**Consultation Response from: KC Environmental Health (Pollution & Noise Control)**
**2025/92961 - Crown House, 12 Southgate, Huddersfield, HD1 1DE**

**Discharge of details reserved by conditions 3 (C(E)MP), 4 (CEMP: Biodiversity), 5 (Air Quality Impact Assessment), 6 (Noise Impact Assessment), 7 (external facing materials), 8 (bin store), 9 (external facing materials), 10 (BEMP), 11 (invasive species protocol), 14 (noise management plan) on previous permission 2022/93932 for change of use of crown house to provide student-only living accommodation (sui generis) in the form of studios (198), with ancillary concierge and communal facilities including an open plan lounge, coffee bar and gym at ground floor, with laundry, car parking, cycle store, parcel store and plant rooms at basement level and associated works including the installation of new cladding and fenestration to the elevations with a new roof garden atop the building**

**Responding Date:  
05 November 2025**
**Responding Officer:  
SR, MN**
**Responding Ref:  
WK202534577**
**Comments**

Figure 1 – Glazing and ventilation specification

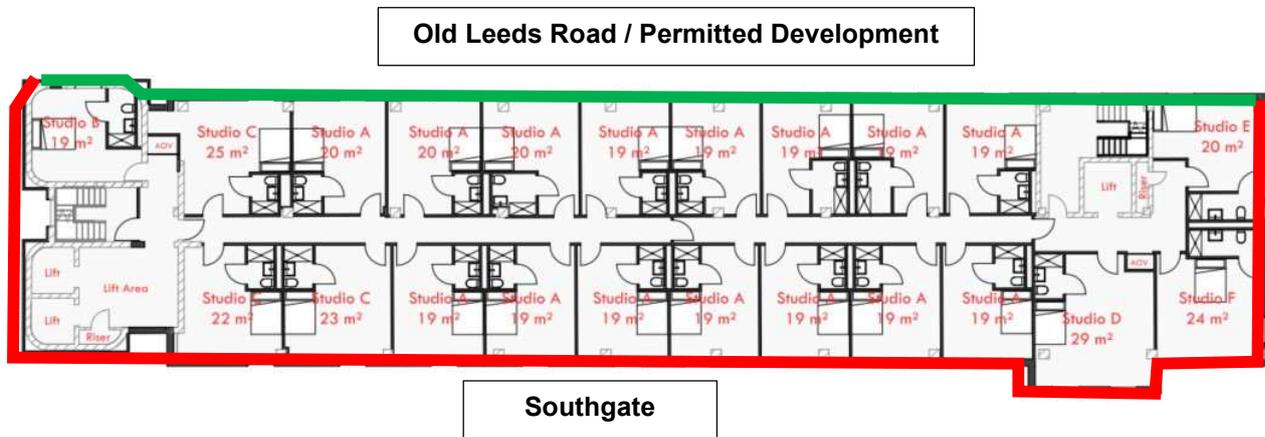
An Acoustic Design Strategy authored by PDA Acoustic Consultants has been submitted dated September 2025 Ref J005131-8042-CW-01. Based upon the findings of a previously submitted noise survey undertaken in 2024, the report recommends glazing and ventilation in order to meet with the internal requirements of BS8233. This is given in colour coded format in figure 1 according to the façade and is based upon reasonable assumptions for the existing construction.

Comment is made that close care and attention to build quality is essential in ensuring the acoustic performance of any construction is maintained and helps to ensure the building meets with the appropriate standard.

The submitted information is accepted. However, we recommend the condition is not discharged until all of the mitigation measures are implemented and retained thereafter.

Figure 1 – Ground floor non-residential spaces.

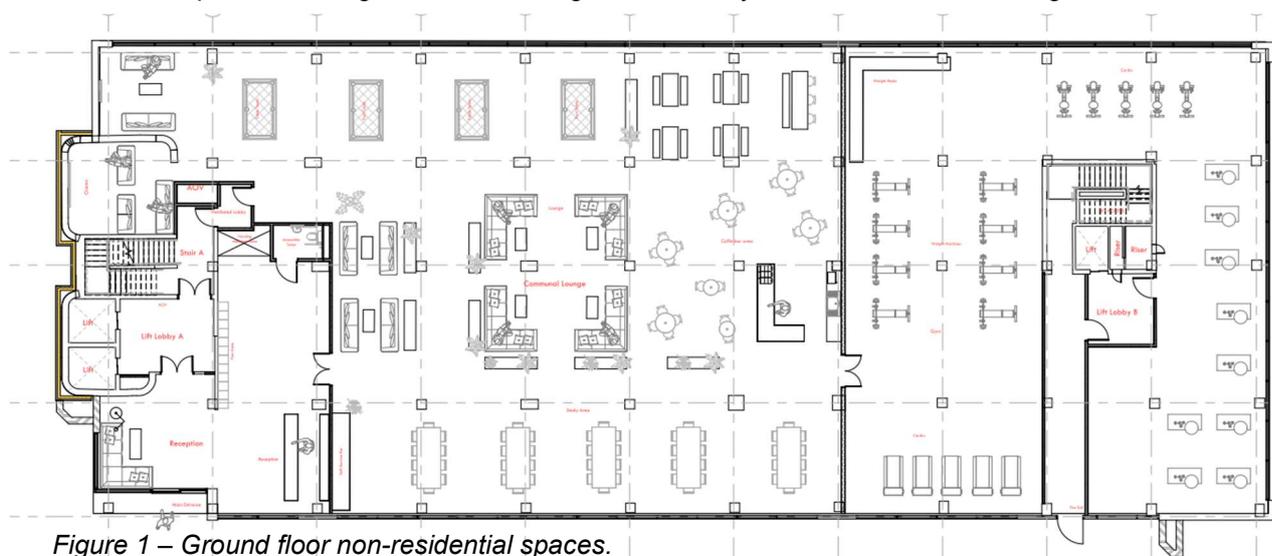
A Noise Management Plan (NMP) authored by PDA Acoustic Consultants has been submitted dated December 2024 Ref J005131-8238-CW-01 which identifies the non-residential uses on the ground floor as shown in figure 1.

The NMP recommends the control measures for the proposed activities including noise limits, curfews along with monitoring and regular review of the NMP in order to ensure compliance with the recommended measures.

The submitted information is accepted. However, this is a compliance condition and must be retained for the duration of the development.
